From: Dunderdale, Chris <Chris.Dunderdale@lancashire.gov.uk>
Sent: 05 November 2018 13:23
To: planning
Subject: RE: 3/2018/0918

Thank you for consulting the Lead Local Flood Authority (LLFA) on the above application. In order for us to properly assess the suitability of the proposal (and to provide you with a substantive response), we would first require the following information to be provided by the applicant:

The application is for a proposed surface water drainage scheme using an underground tank placed beneath the shared private driveways for plots 83-89 (numbers 26 to 38 Tintagel Way, Clitheroe BB7 2RL).

PLAN VIEW
Scale - 1:500

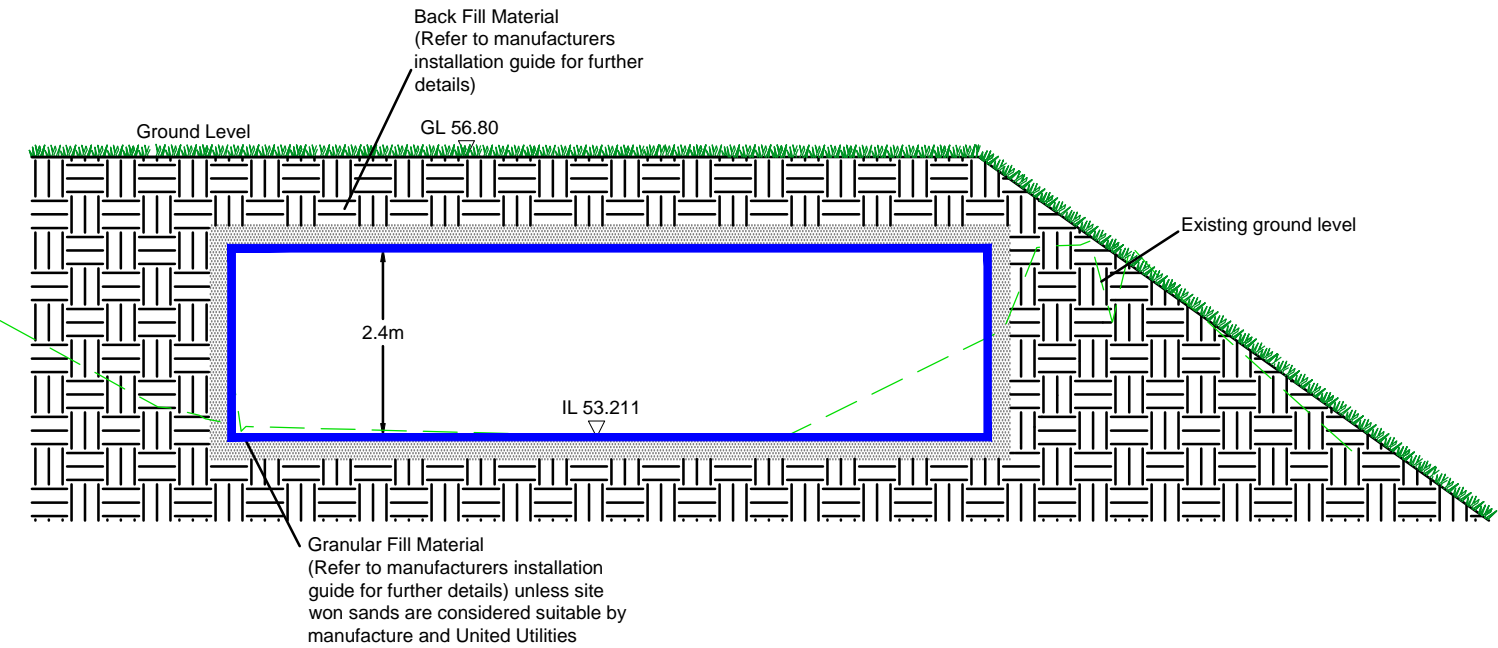
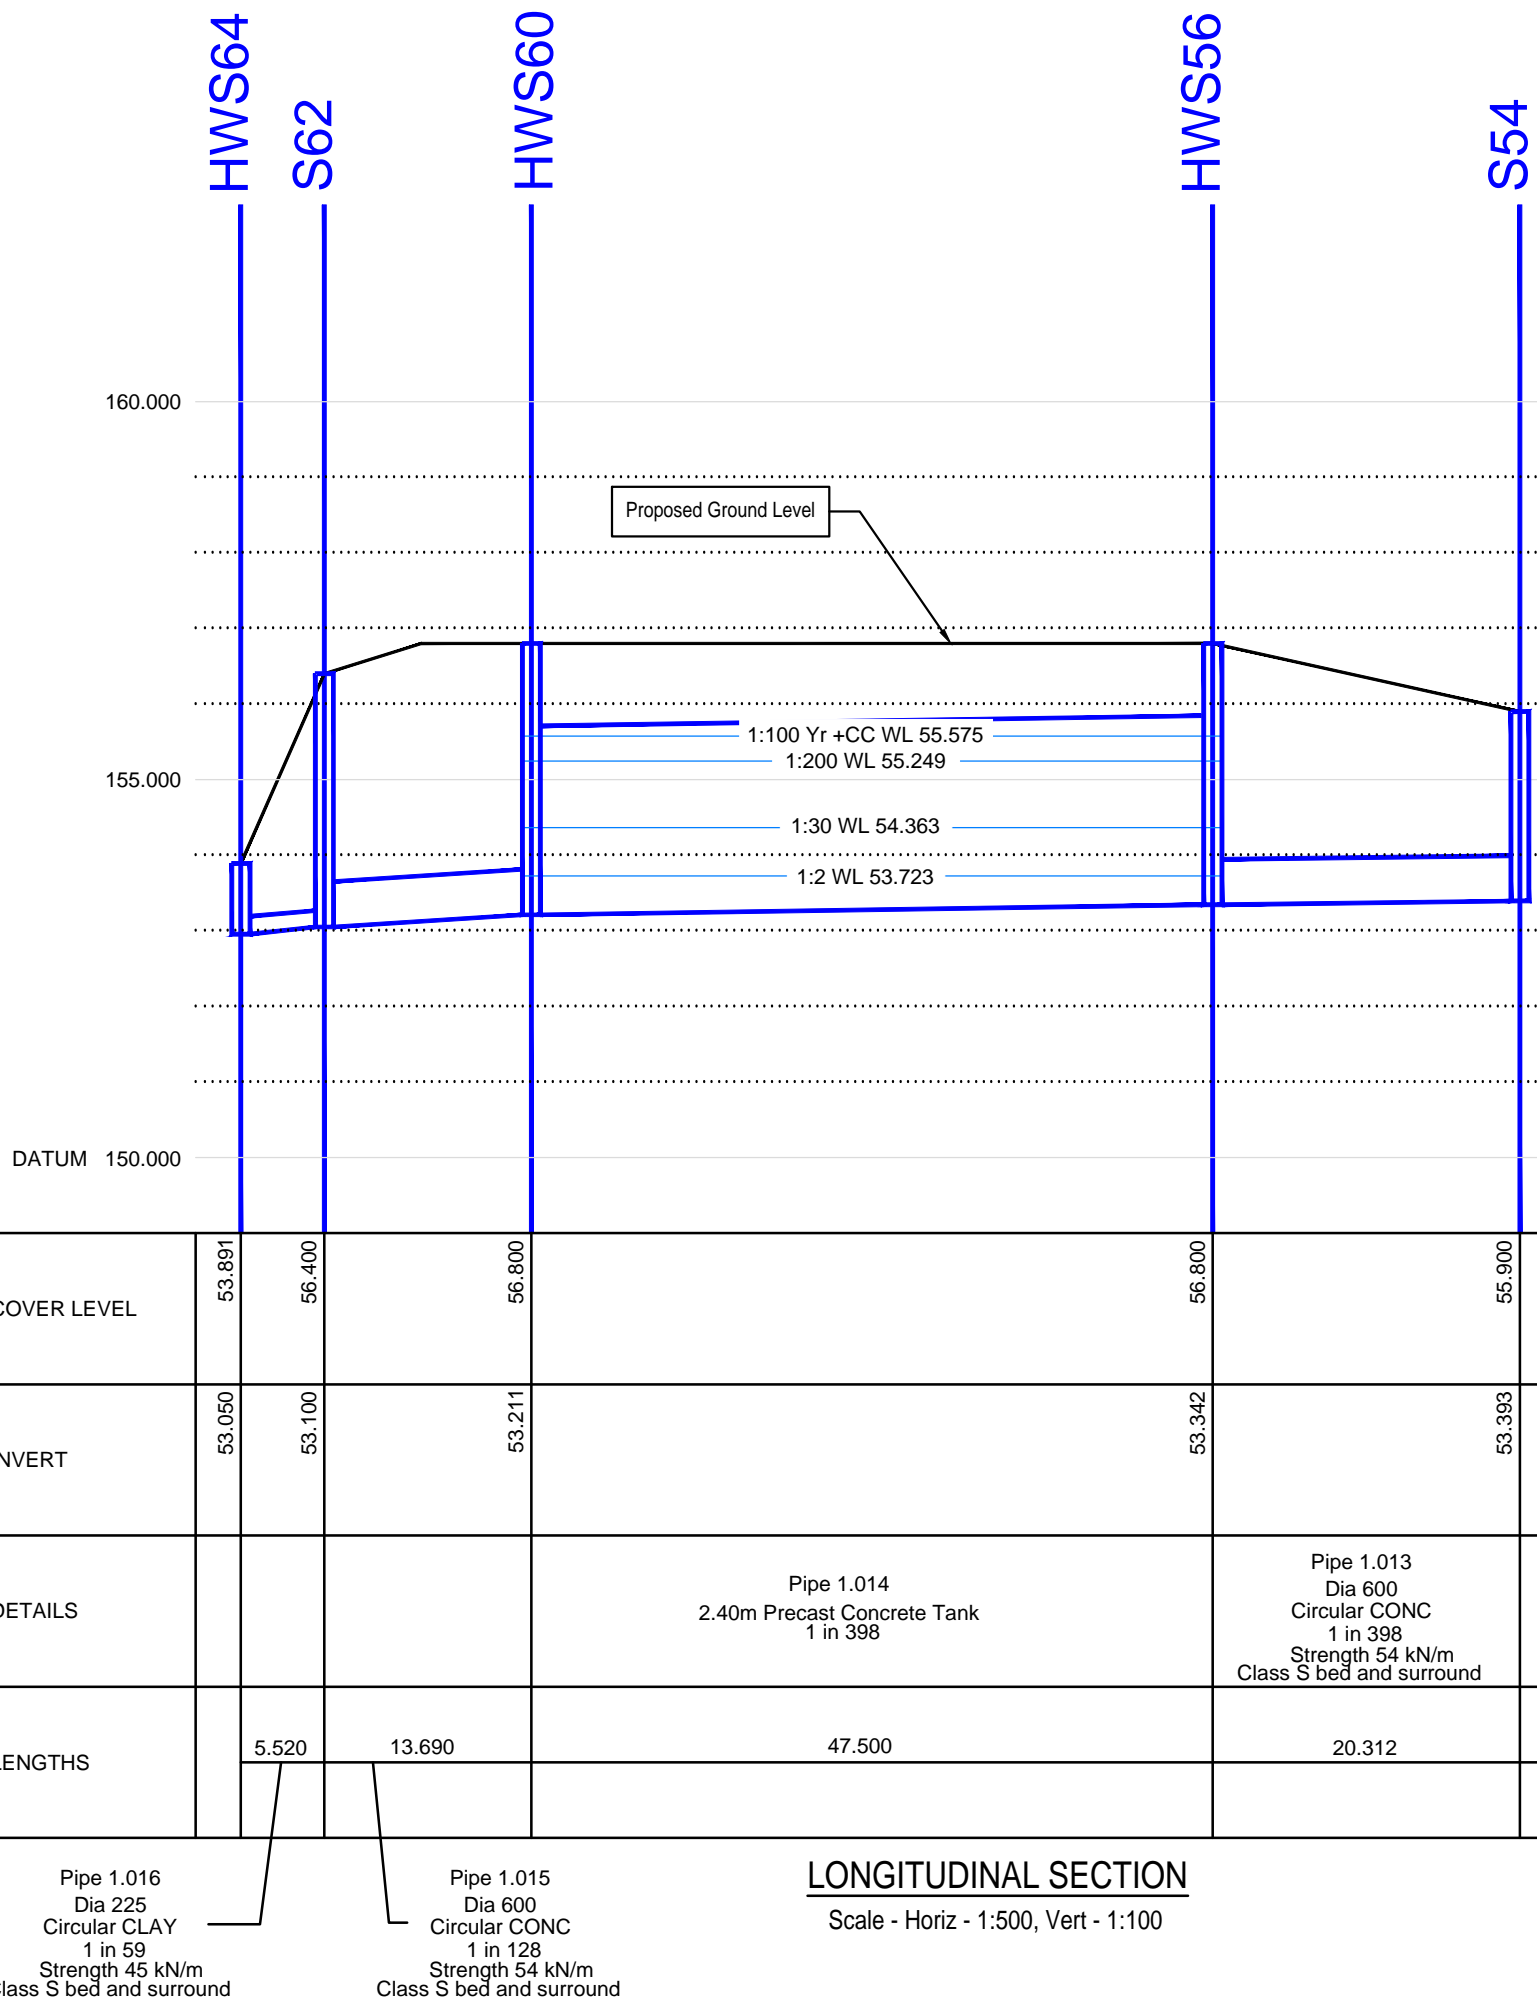
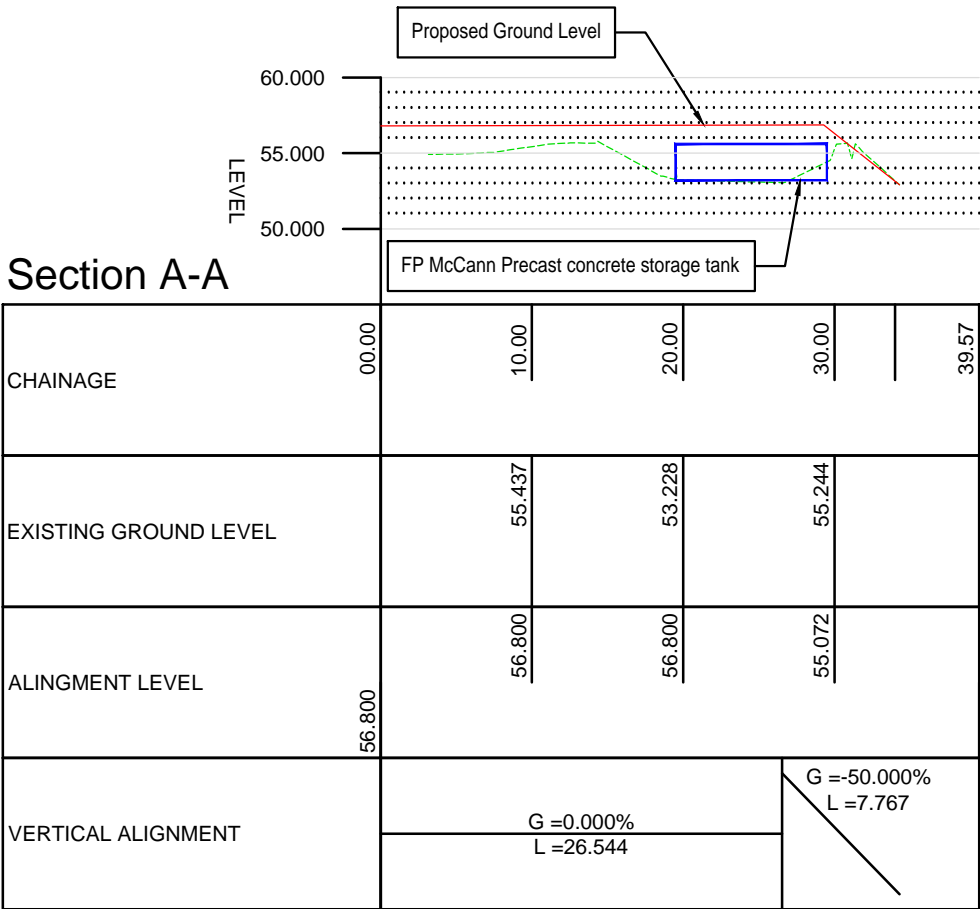
- a) A revised surface water drainage layout plan that covers the whole development site. The revised plan should include all relevant pipe/structure references, dimensions and design levels so that the plan can be cross referenced with the supporting flow calculations.
